Rezoning Transportation Analysis

Petition Number: 2020-099

Date	Description
08-20-20	First Review
09-22-20	Second Review
10-28-20	Third Review (KP)

The site is located along Mallard Creek Road (major thoroughfare, state-maintained) and Penninger Circle (local street, city-maintained). The site is in a wedge outside Route 4.

REVISIONS:						REV REVISION DESCRIPTION DATE: CHANGED CHEC
DATE:	DESIGN BY:	DRAWN BY:	CHECKED BY:	APPROVED BY:		
	Mallard Creek Townhomes		Charlotte, NC		Bezoning Plan	
): 651032401			09/14/20

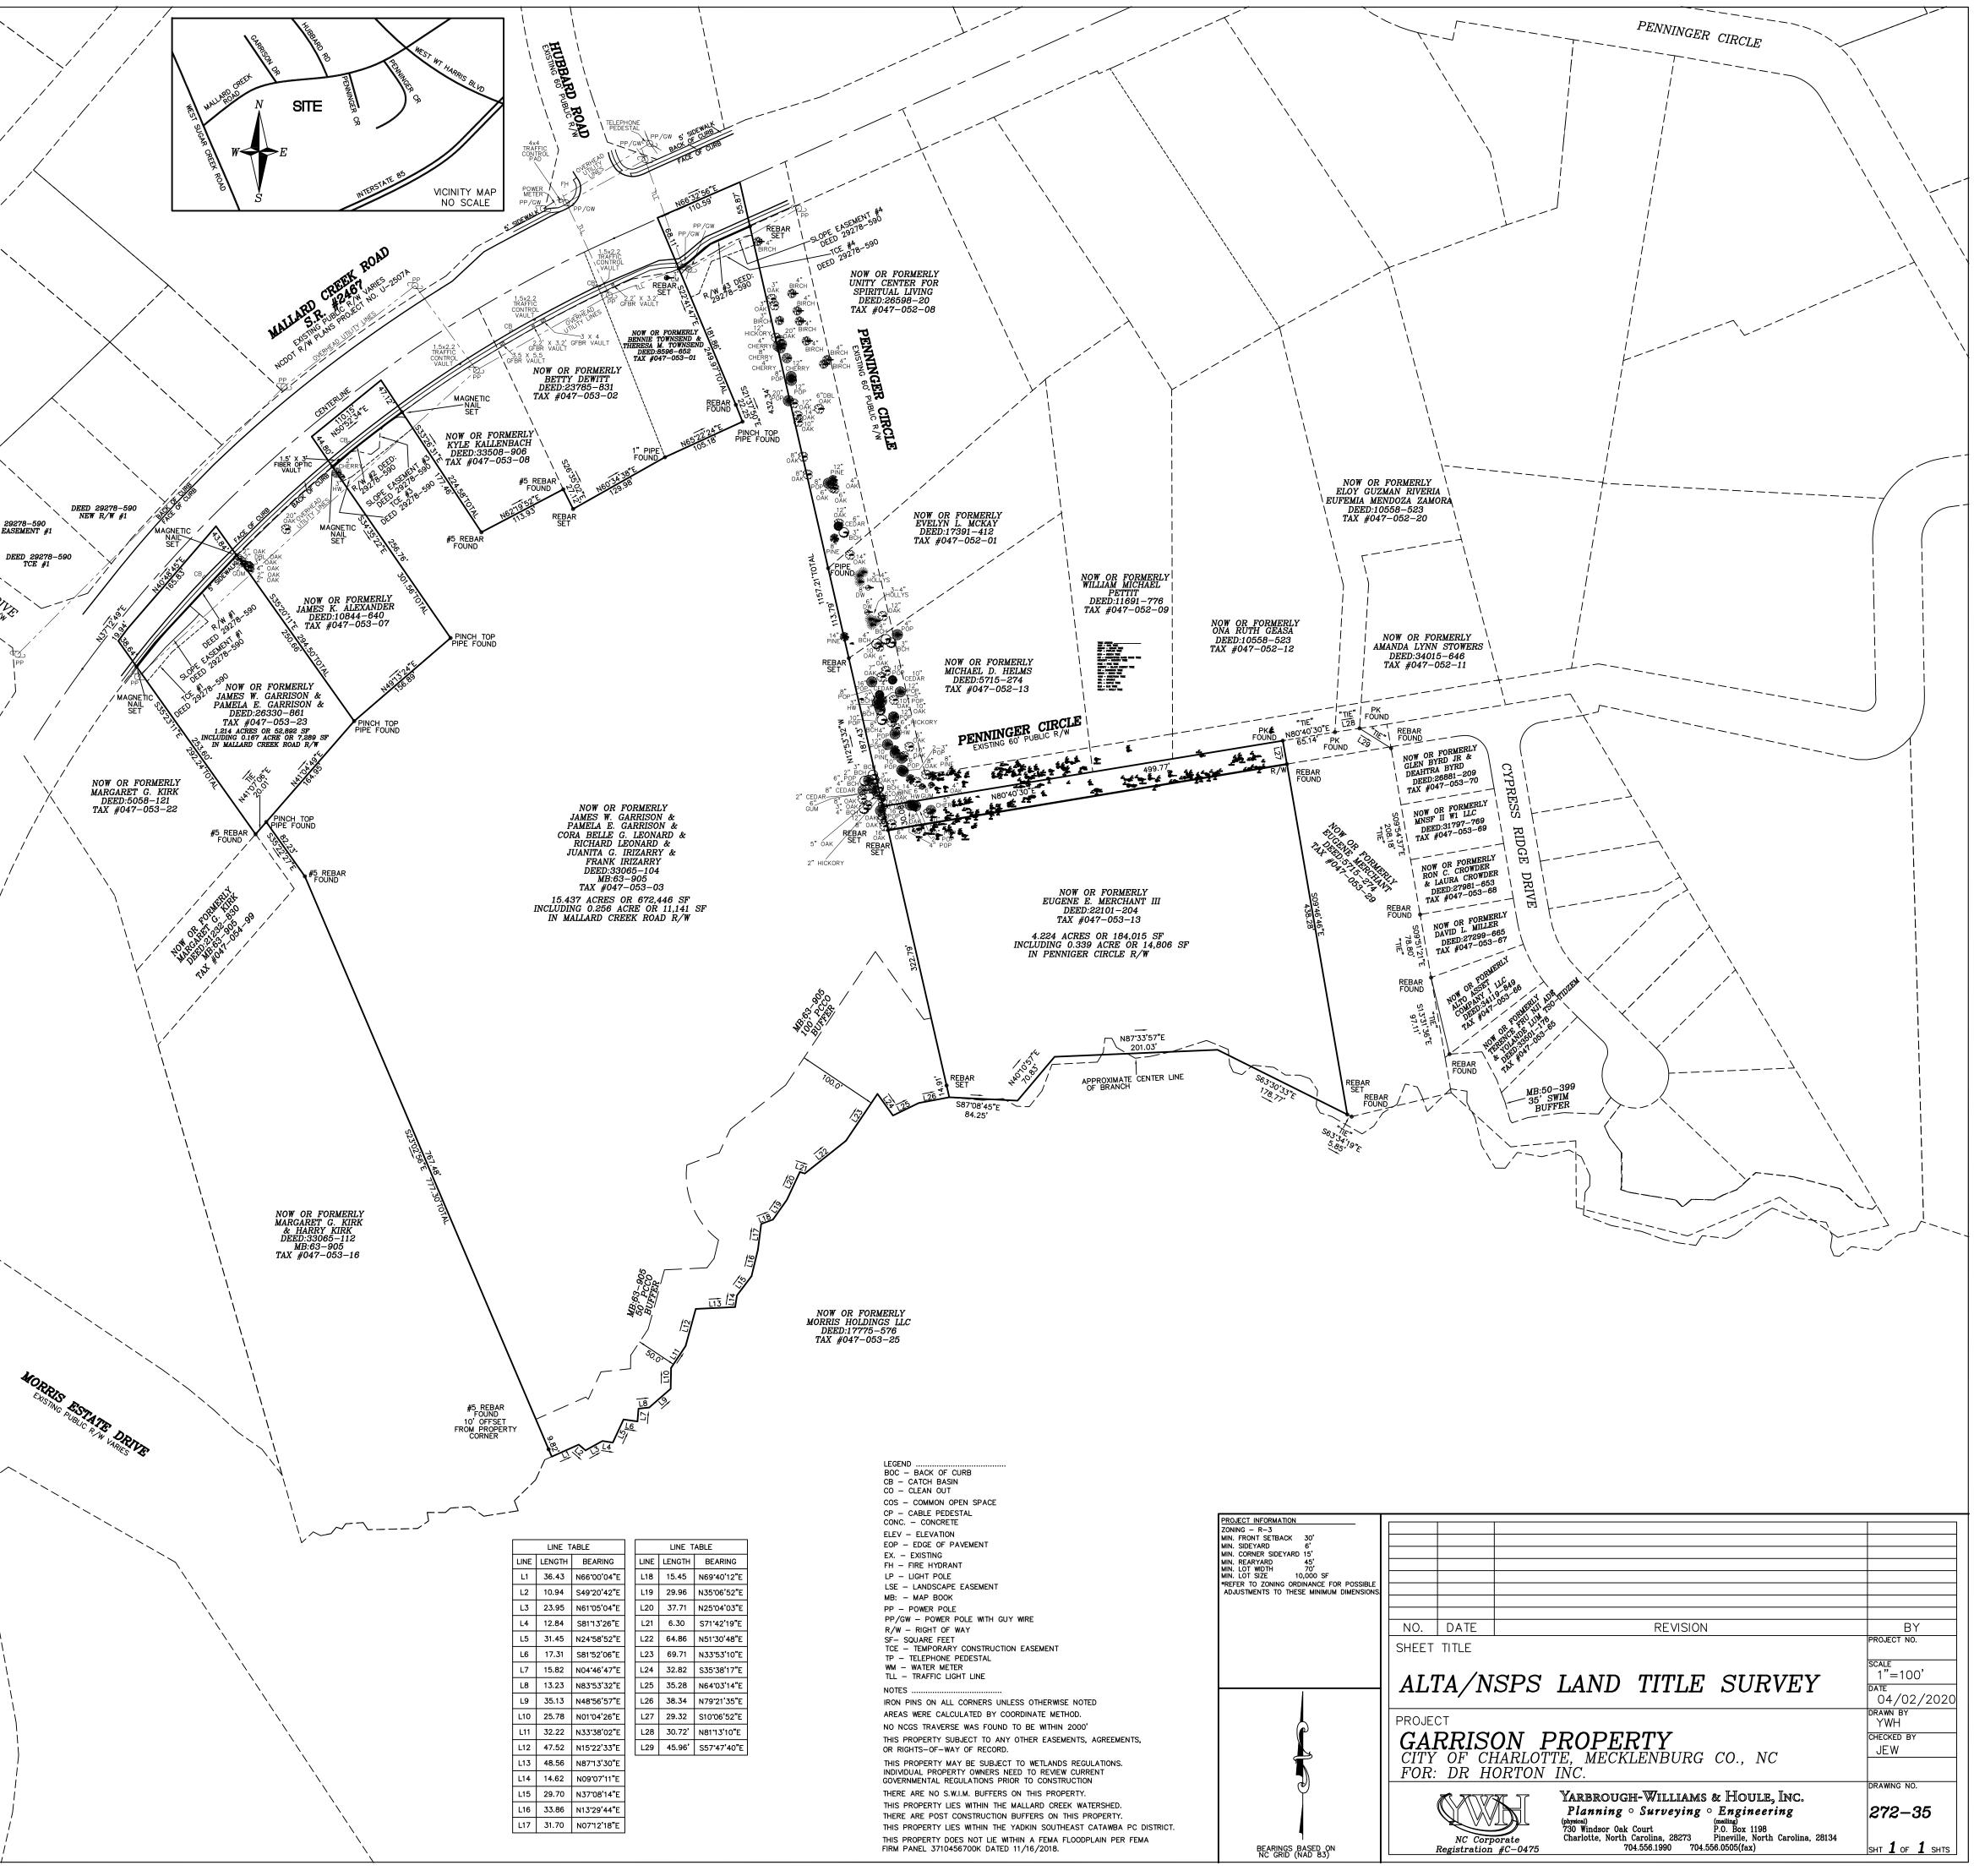
- a. ~~**Technical Clarification (site plan dated 09/14/20)** The petitioner should clarify conditional note (Section 3.C.) that 2-ft of additional right-of-way should be dedicated from back of the 12-ft multi-use path. The petitioner should construct a 12-ft multi-use path where the existing sidewalk is removed for the proposed right turn lane. Where the existing sidewalk remains undisturbed along the property frontage, CDOT requests for the existing sidewalk to be widened to 12-ft, in accordance with Charlotte BIKES.~~

- a. **Technical Clarification (site plan dated 09/14/20)** The petitioner should clarify whether front-loaded or rear-loaded units are proposed. If front-loaded, the petitioner should commit to pair shared driveway aprons with every two units, to preserve the proposed planting strip and sidewalk within the public right of way. This request limits the number of curb cuts, promotes walkability, and preserves a quality streetscape.

- a. ~~**Technical Clarification (site plan dated 09/14/20)** The petitioner should clarify conditional note (Section 3.D.) that a proposed right-turn lane will be constructed at the proposed Mallard Creek Road right-in/right-out access. The proposed right-turn lane should have 100 linear feet of storage with the appropriate bay taper length, according to NCDOT design standards.~~

- a. ~~**Technical Clarification (site plan dated 09/14/20)** The petitioner should clarify the site plan to show and call-out the existing Penninger Circle private drive that ties into existing Mallard Creek Road. CDOT requests the petitioner to clarify that the existing Penninger Circle road improvements will be constructed in accordance with CLDSMU-02 - Local Residential Medium Section cross section design standards, on both sides of the existing Penninger Circle road centerline.~~
